Lane Cove Society Inc

SSD-8699 Development of the Greenwich Hospital site, River Road, Greenwich.

DRAWING TITLE:
SITE SECTIONS
DATE:
AUGUST 2019
DRAWN:
ML, JC
PROJ:
1213
PROJ ARCH:
BF
DRAWING:
S.04
SCALE:
As indicated @ A1
REVISION:
P5

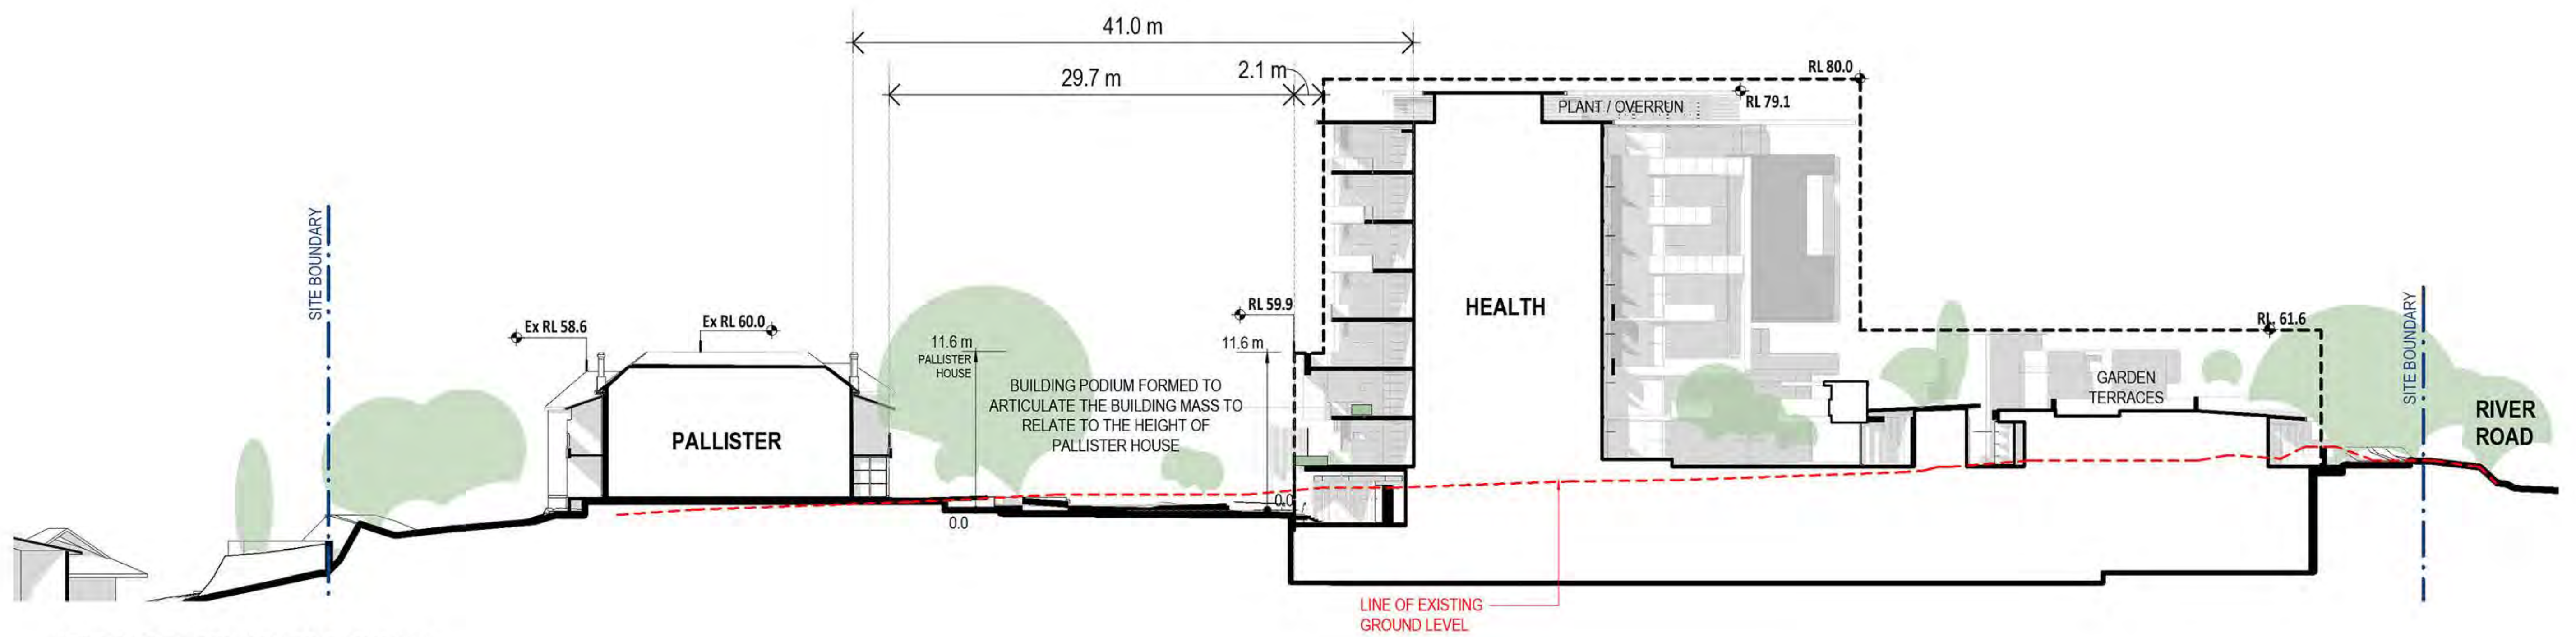
The Report makes findings based on EIS drawings which are misleading as have misrepresented the height of Pallister House roof, gutters and trees, as Pallister House roofline is inflated - higher than it is in relation to the hospital, as shown in drawing S 03/T3 used in the Heritage Report. **Therefore, the conclusions drawn are inaccurate.**

## 2.1 Key Landscape Plan

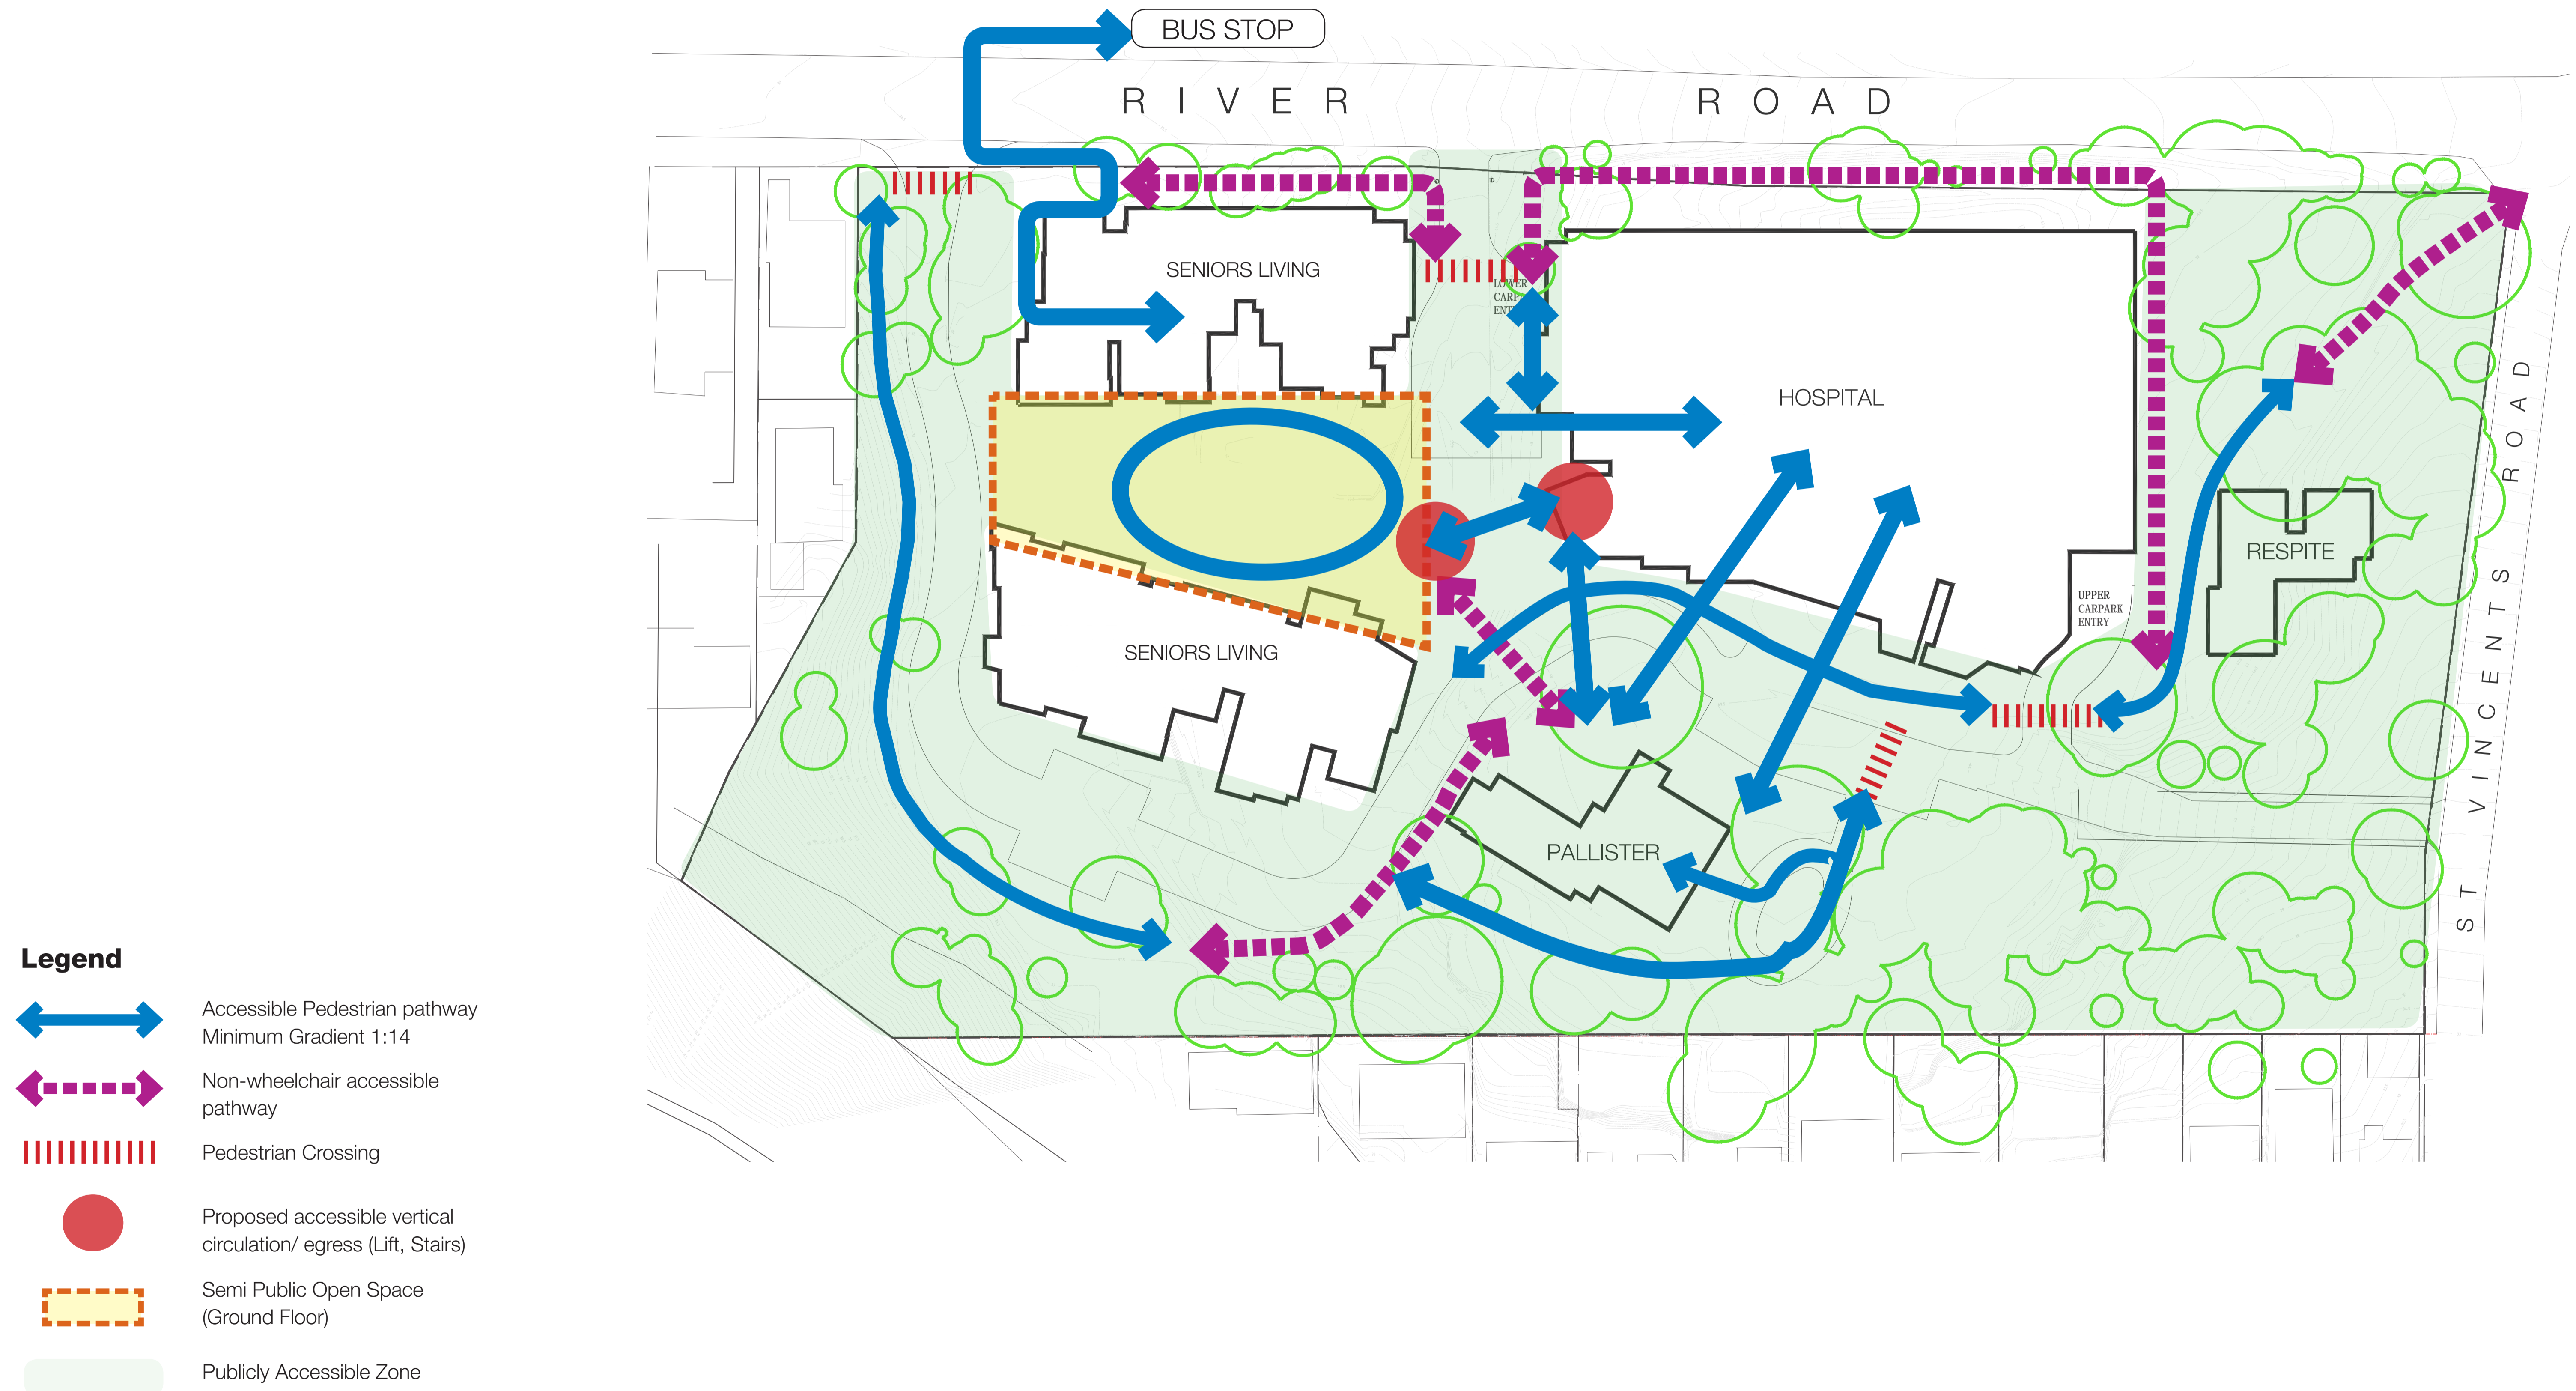
The Arborists Report notes for removal of trees from the Hospital development, as 'Remove & replace with new plantings as per Landscape Plan'. However, there is presently no Landscape Plan. There is a 'Landscape Package' (Appendix L) which outlies the major landscaping zones and their key design principles but is 'broad brush' in nature. It does not describe, recommend or mandate indigenous planting, nor make any reference to **Lane Cove Council's DCP Part J Landscaping**.

R: The Landscape Plan has ignored the existing topography, bushland and trees and used the inaccurate "area not surveyed" version of contours and trees.
